Cartesian Surveys Inc.
PO Box 44414, Rio Rancho, NM 87174
896-3050 Fax 891-0244

**Re: Preliminary / Final Plat Review for Proposed Subdivision Plat of
Lot 1-A, Block 7, Waggonman-Denison Addition**

Cartesian Surveys is acting as an agent for SLN Properties LLC, the owner for Lots 1 thru 7, 17, 18 and "X" of Block 7 in Waggonman-Denison Addition. We request a preliminary / final plat review of a proposed minor subdivision to consolidate 10 existing lots into 1 new lot.

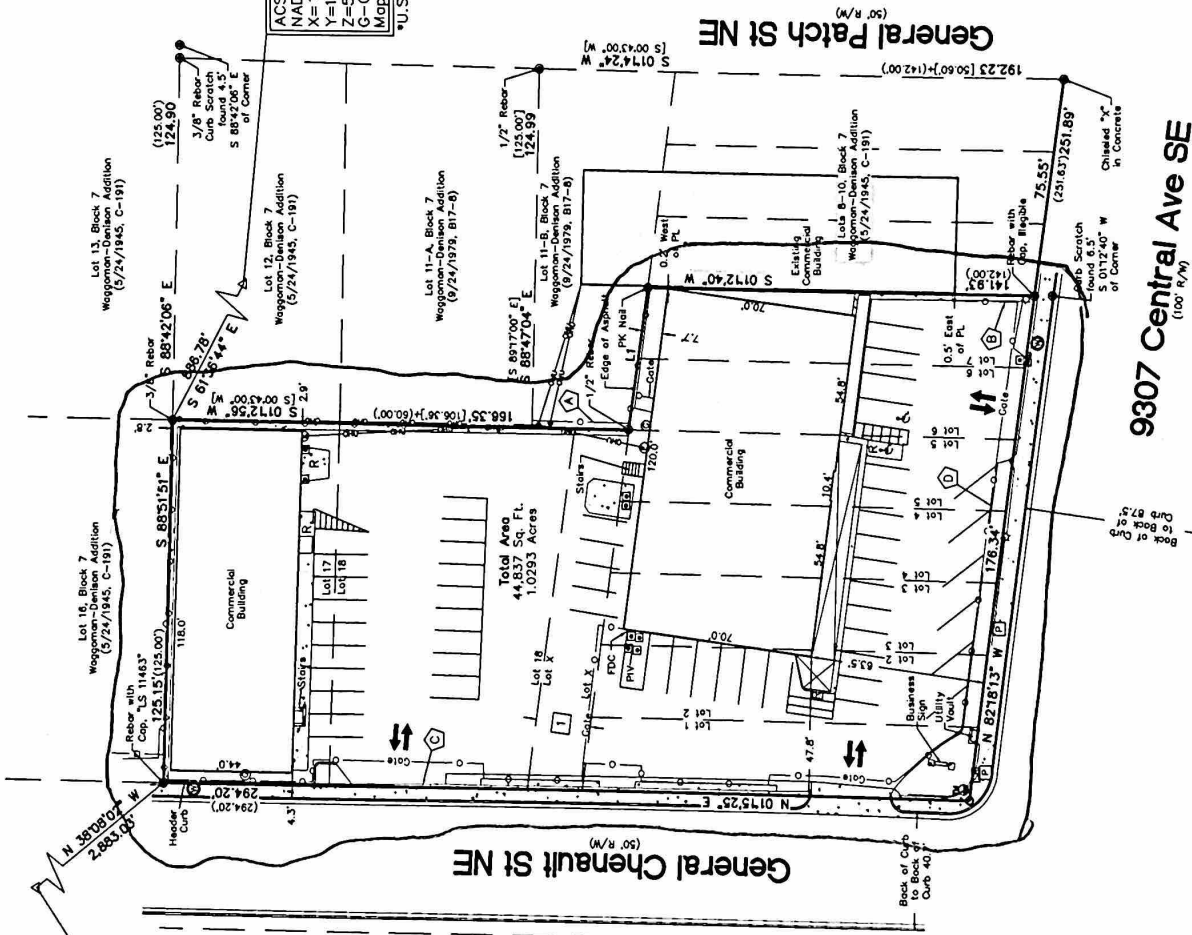
1. Central is a Principal Arterial within a Premium Transit Corridor and requires 8' to 10' sidewalk with a 6' to 8' landscape buffer. General Chennault and General Patch are local

roads and require 5' sidewalk with a 5' to 6' landscape buffer. Provide radius at property corners at the street intersections. Take clear sight distances into account as well as making sure all public infrastructure is within right-of-way. Also, all private infrastructure shall be kept outside of public right-of-way with any adjustments.

Noted, dedication of additional right-of-way allows for widening of sidewalk up to 5 feet along General Chennault and to 8 feet along Central Ave to the proposed property line / existing iron fencing. Landscaping with grasses and trees is provided behind the fencing along property line.
